Our Ref: EN020028

Date: 18 November 2024

Application by Morgan Offshore Wind Limited and Morecambe Offshore Windfarm Limited for an Order Granting Development Consent for the Morgan and Morecambe Offshore Wind Farms Transmission Assets project

Advice following issue of decision to accept the application for examination

Onshore historic or scheduled monument sites (Doc B16)

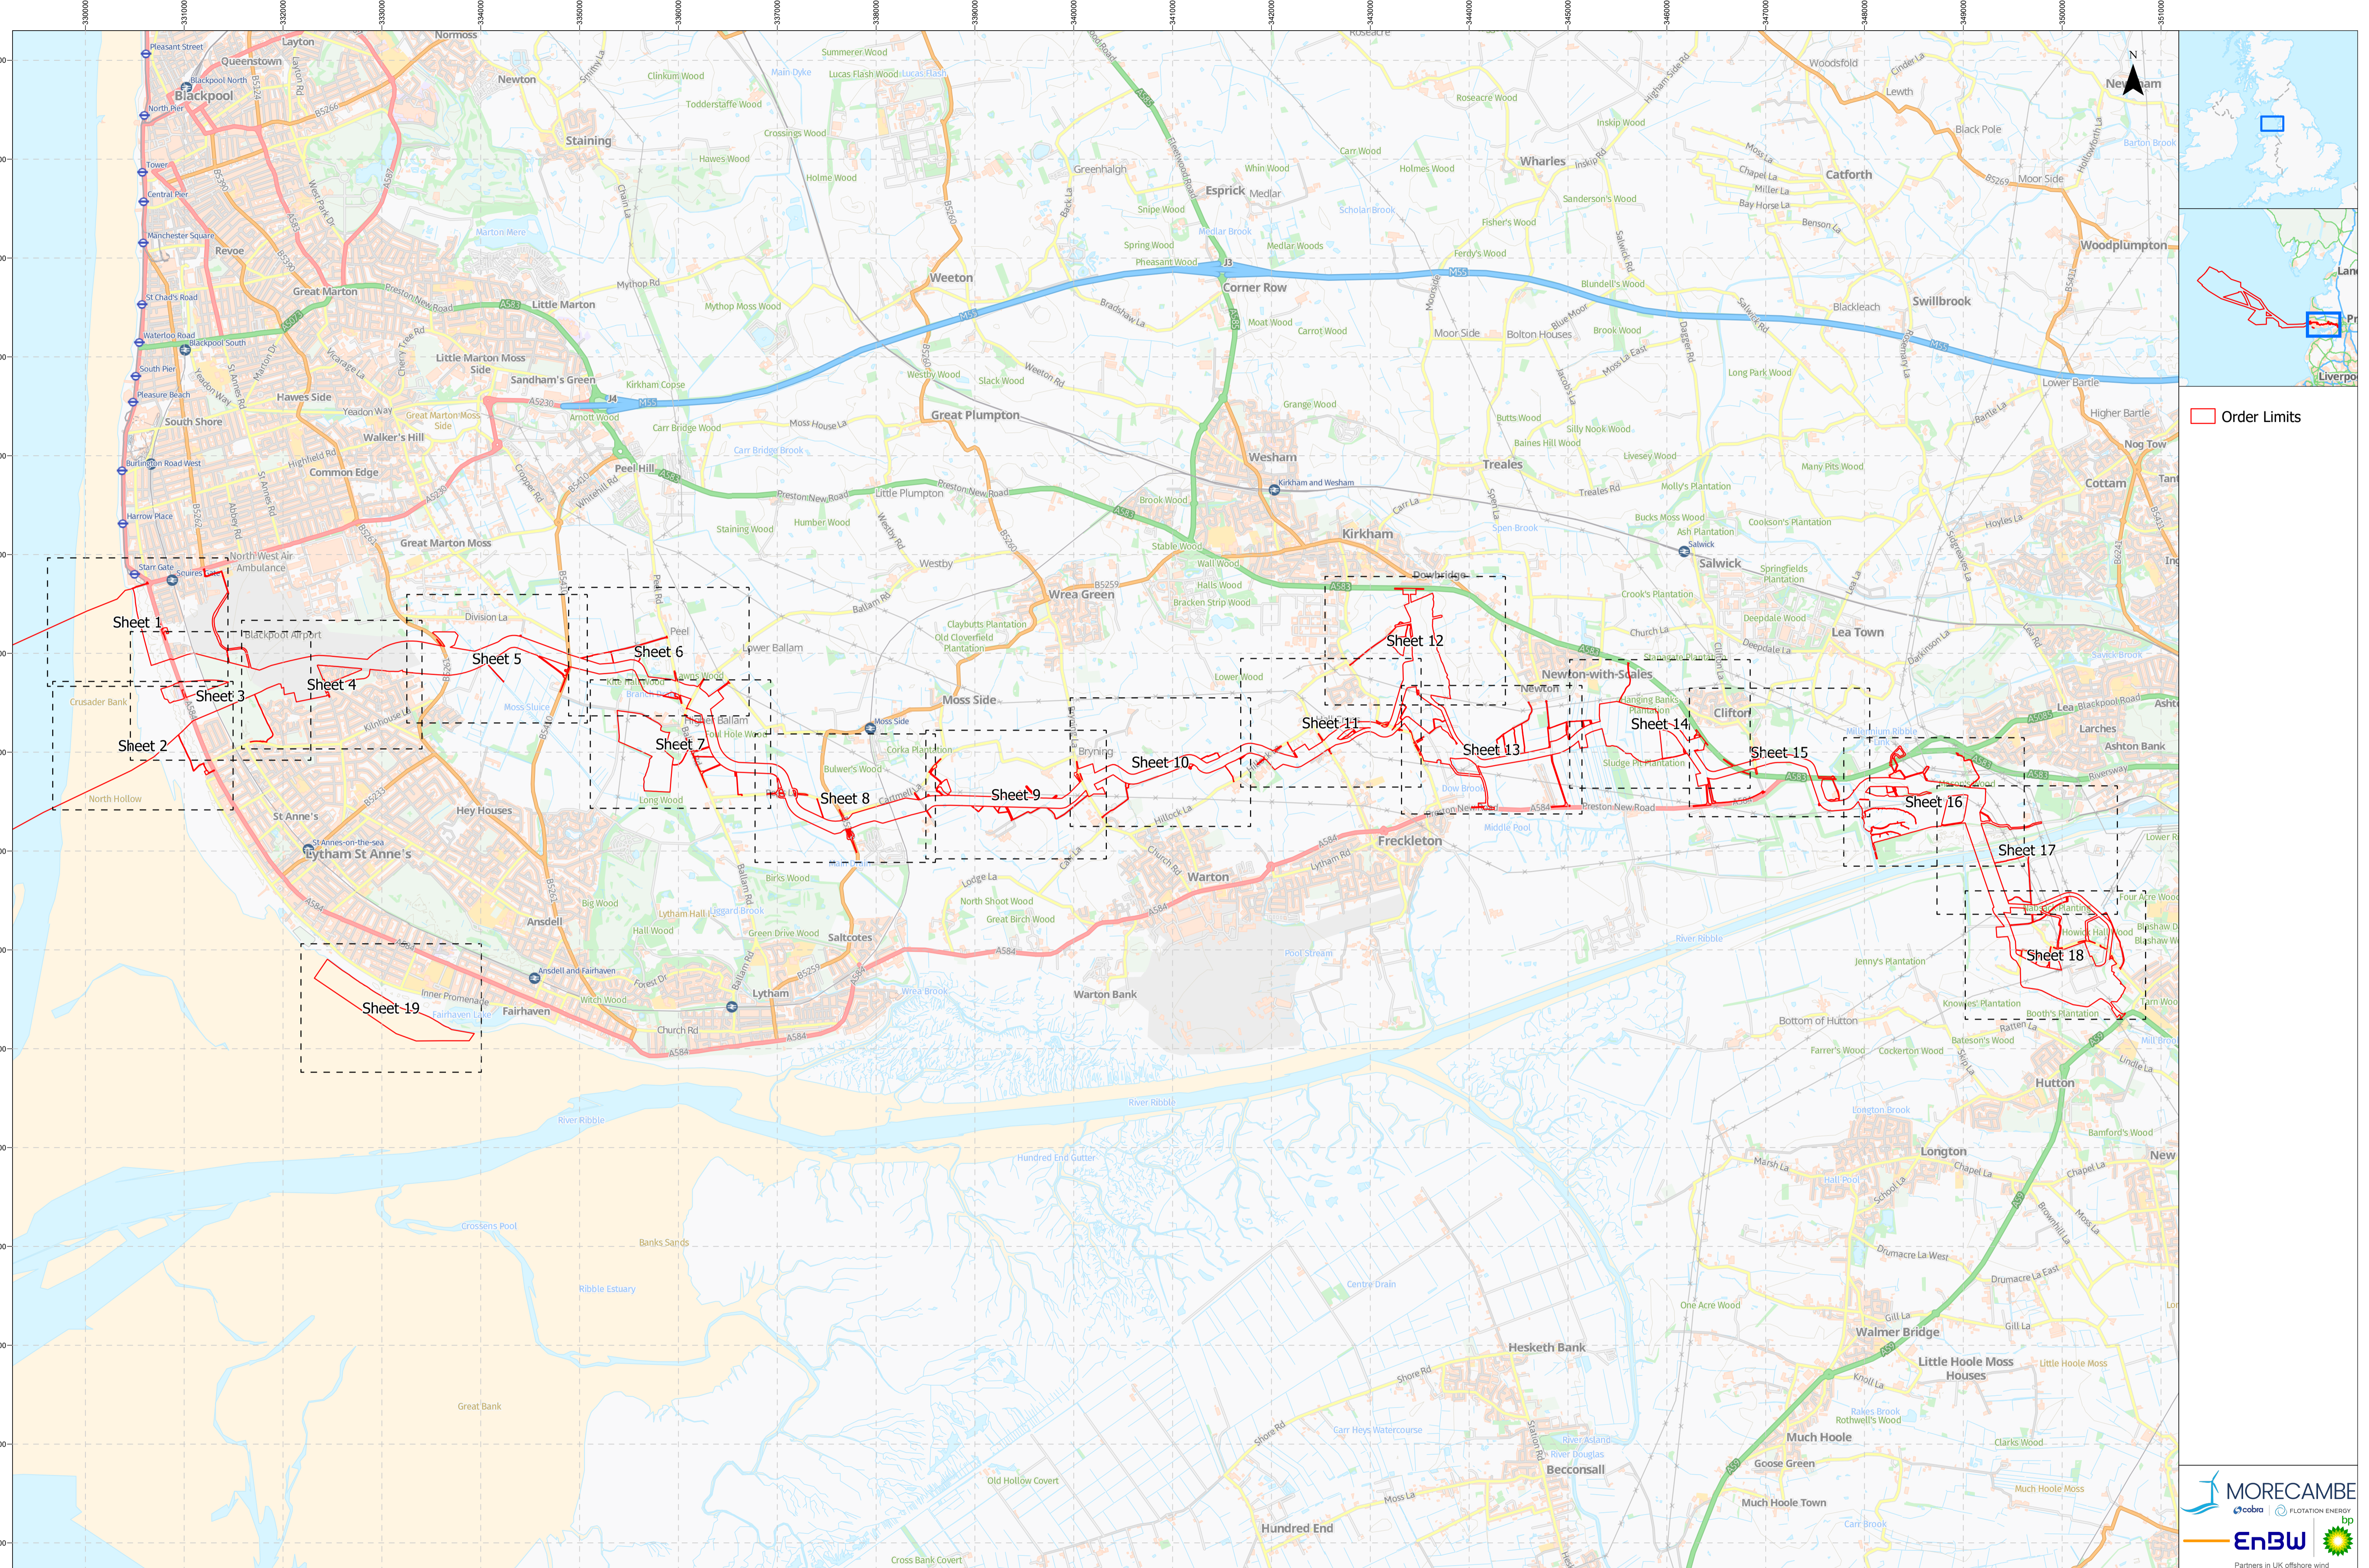
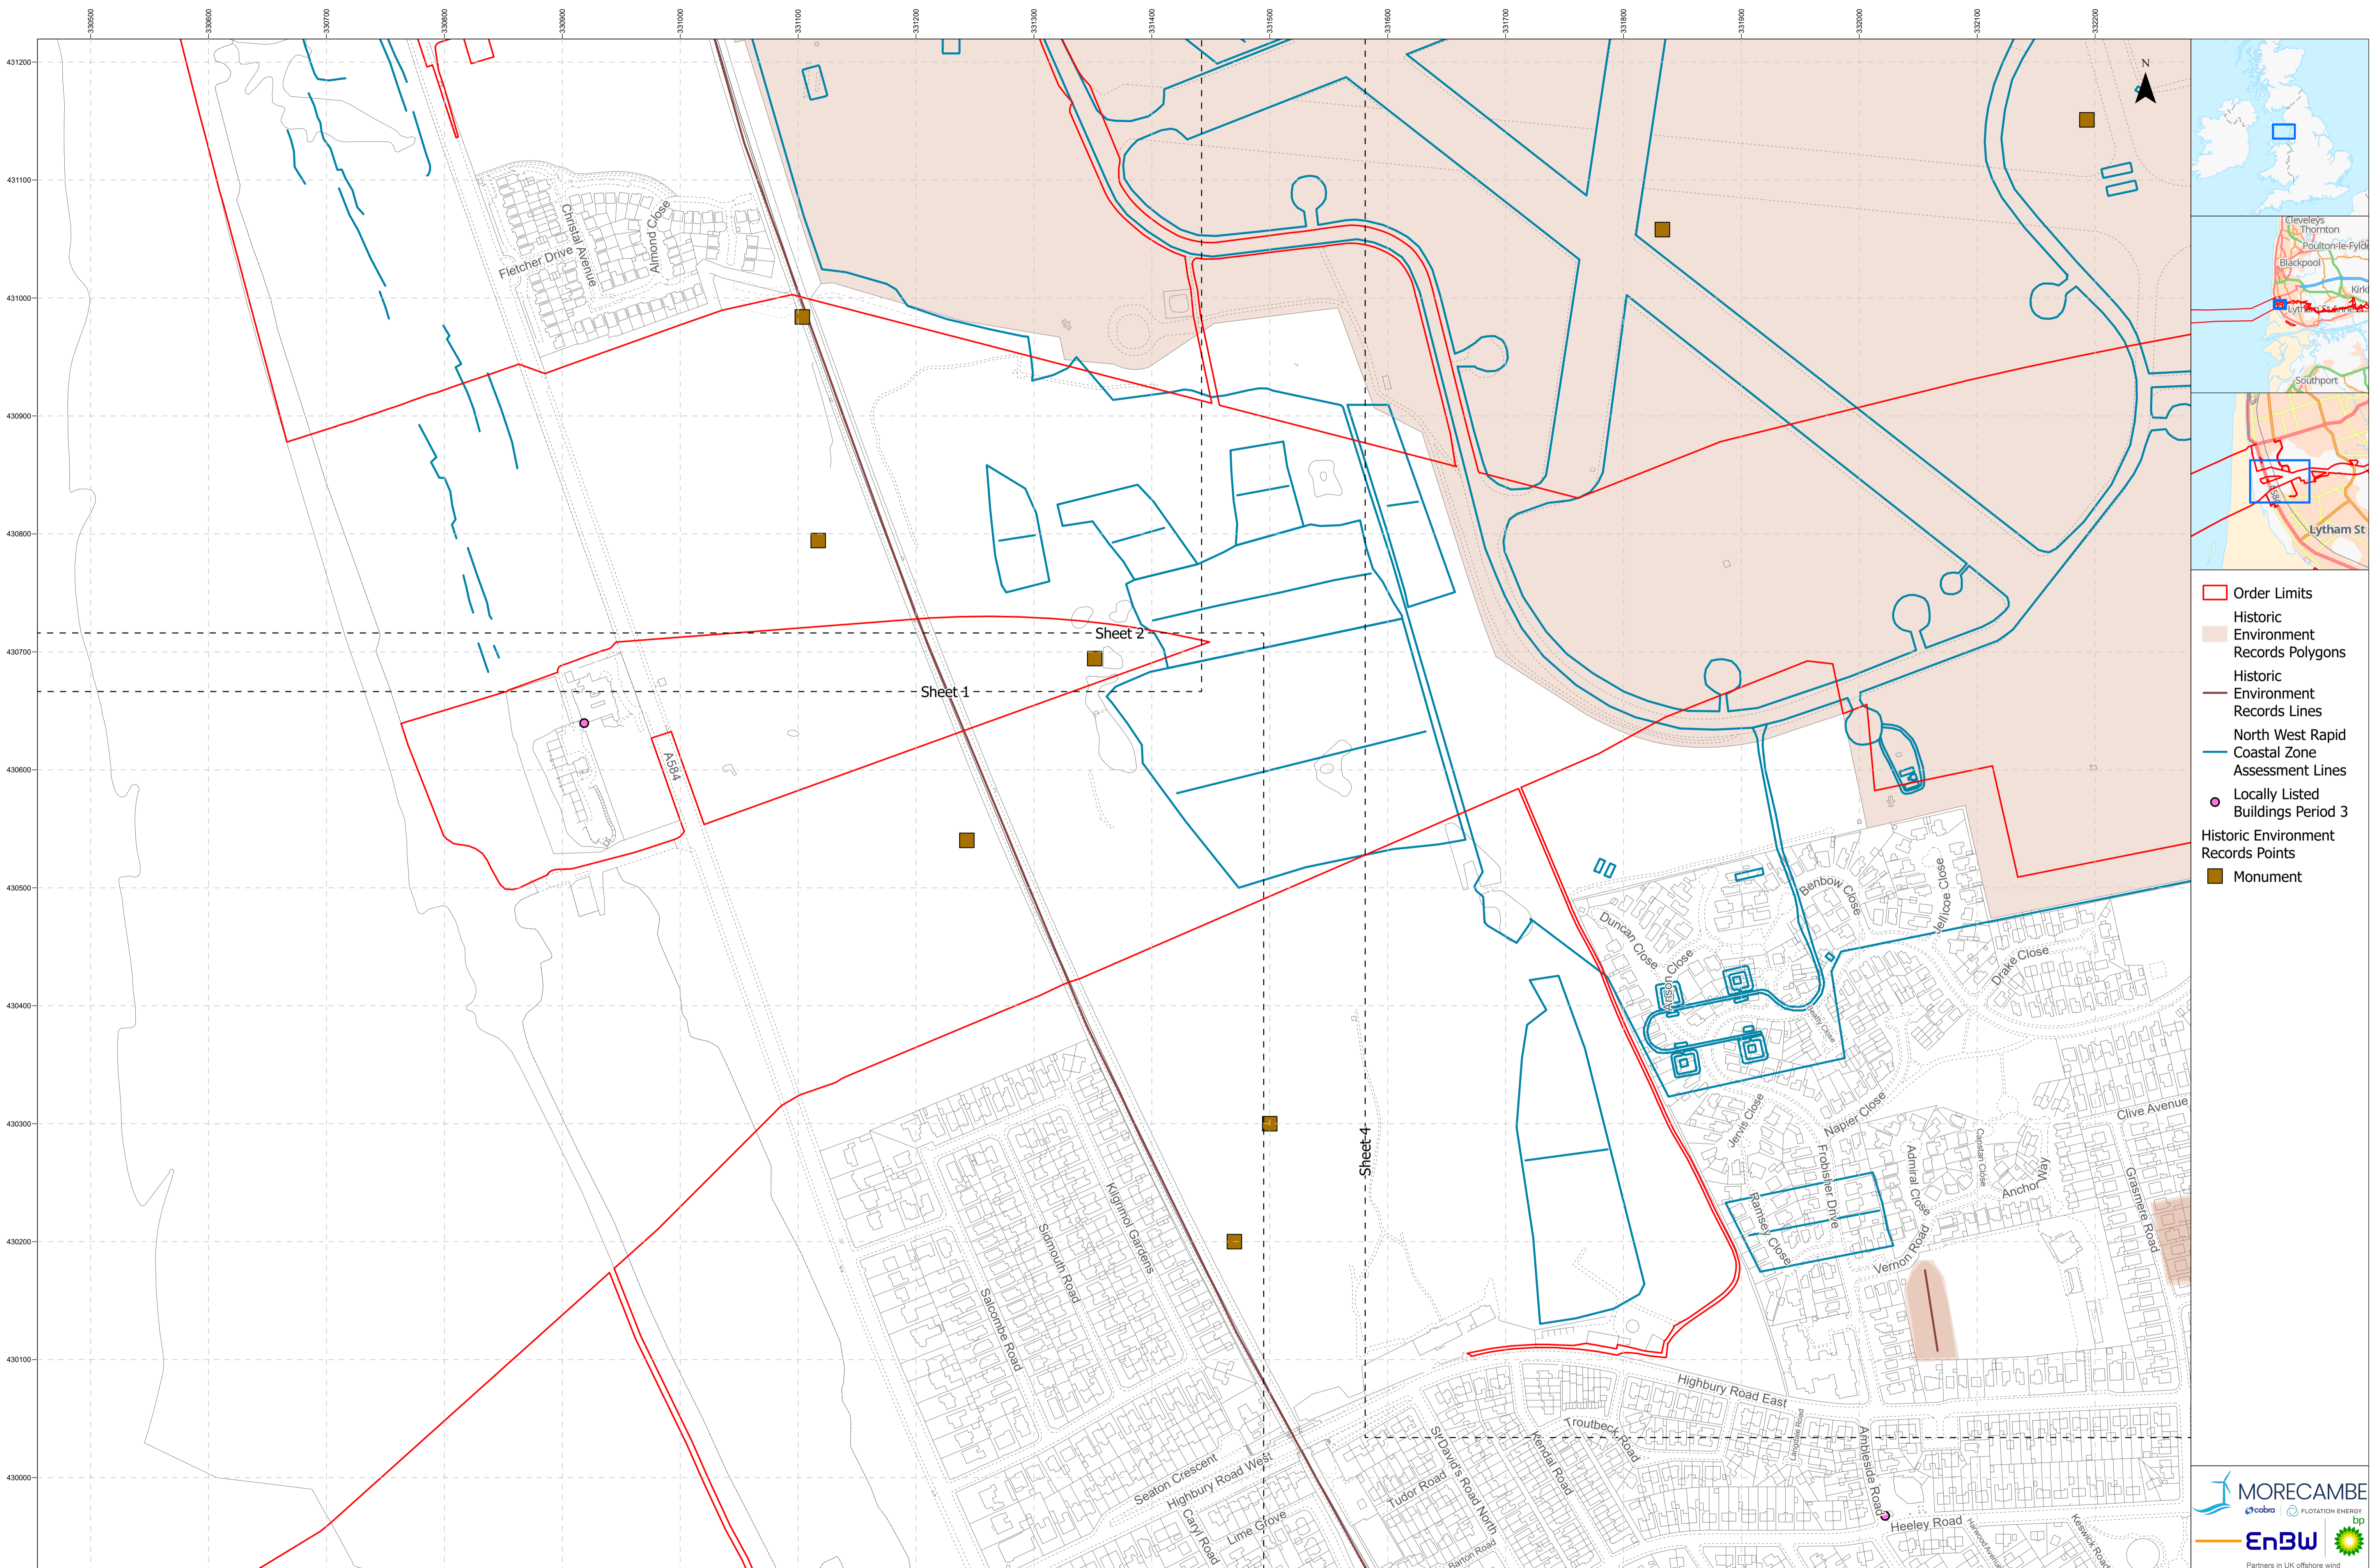
Between the onshore historic or scheduled monument sites (Doc B16) and ES Volume 3 (Doc F3.12, figures for chapter 5), there appear to be some minor differences in terms of the specific assets recorded between these drawings. An example is Doc F3.12 ES figure 5.7 compared to sheet 3 of Doc B16. The Applicants are advised to provide an updated set of figures which are consistent in the features being represented, with appropriate labelling.
